NORTH FALLS OFFSHORE WIND FARM

Appendix H5 to the Natural England Deadline 5 Submission

Natural England's comments on 7.2.2.2 HRA Annex 2B HRA Annex 2B Lesser Black-backed Gull Compensation Effects on Designated Sites (Rev 0) [REP4-010]

30 May 2025

Figure 2 Indicative maximum fence line and associated works

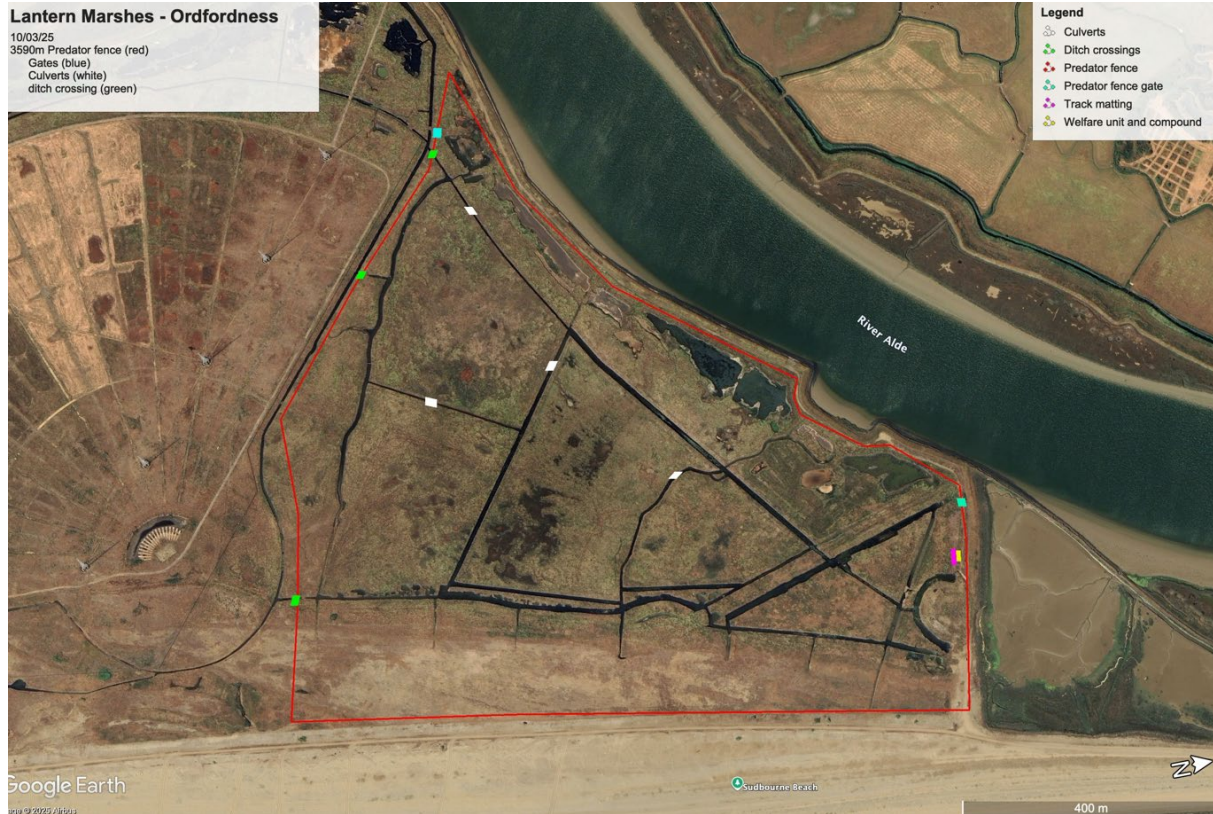
need to consider the risks to compensation delivery of flooding events at this preferred site option.	
[REP4-010] 7.2.2.2 HRA Annex 2B LBBG Comp... (Rev 0)	We note in Paragraph 22 that the proposed fence installation and maintenance works would take place for 3 months (10-12 weeks) outside of the LBBG breeding season to avoid impacts on breeding bird receptors. There is limited consideration of impacts on overwintering bird receptors and conclusions are based on the works being temporary and short term (3 months). The value of Lantern Marshes for SPA/Ramsar site non-breeding birds has not been established, and we highlight that it is an undisturbed area of the site and therefore may support significant numbers of waterbirds. The Applicant will need to fully consider impacts to overwintering birds and if/where necessary mitigation to reduce impacts (including seasonal restrictions). Monthly Wetland Bird Survey (WeBS) and other data sources should be sought in order to understand the importance of the site on a month-by-month basis, and also whether parts of the site are more sensitive than others to ensure the mitigation strategy is appropriate for non-breeding waterbirds.	No

[REP4-010] 7.2.2.2 HRA Annex 2B LBBG Comp... (Rev 0)	It is stated in Paragraph 36 that as a worst-case scenario the fence may need to be fully replaced after approximately 20 years. However, the life of the compensation measure would be longer than the life of the predator fencing. This would lead to a repeat of the original installation impacts, and then further impacts upon decommissioning of the compensation measure. Whilst this is considered in the HRA, in line with our advice above we are concerned that the impact conclusions are based on assumptions and a lack of robust supporting evidence. This evidence will need to be gathered prior to construction and inform a mitigation strategy.	No
[REP4-010] 7.2.2.2 HRA Annex 2B LBBG Comp... (Rev 0)	In Section 3.2.7, perennial vegetation of stony banks was initially screened into assessment. However, in Table 3.5 it was subsequently screened out of the assessment because the only vegetated shingle potential habitat within the project area is already used as an access track. However, we consider that vehicles using that track are likely to differ (in weight and frequency) from those employed during construction and highlight that no surveys have been undertaken to confirm that the habitat is 'low quality' and not supporting designated flora/fauna.	No

Document reviewed: 7.2.2.2 HRA Annex LBBG Compensation (Rev 0) [REP4-010]			
NE Ref	Section	Key Concern and/or Update	Natural England's Advice to Resolve Issue
1	2.1.2	The fence works will include scraping an area 3,590m long to a maximum 1m wide and 0.1m deep (0.36ha) of habitat that has not been site specifically surveyed.	Site specific habitat surveys will need to be carried out for the proposed fence works area and be used to update fence design and installation plans as required, including mitigation where a need is identified.
2	General comment	No assessment of the value of the site to overwintering birds within the context of the SPA/Ramsar site/SSSI as a whole has been made.	The value of the site to overwintering SPA/Ramsar site/ SSSI birds will need to be assessed, and relevant assessments updated accordingly.
3	Para 78	It is stated in Paragraph 78 that consideration has been given to the potential for run-off from construction into the coastal lagoons. However, supporting evidence has not been included on the sensitivity of the lagoons that may be affected by the proposed works, despite quoting the Abrehart Ecology Ltd, 2022 report. This concern also applies to the vascular plant and invertebrate assemblages that may be affected by the proposed works	Supporting evidence will need to be provided on the sensitivity of coastal lagoons that may be affected by the proposed works.
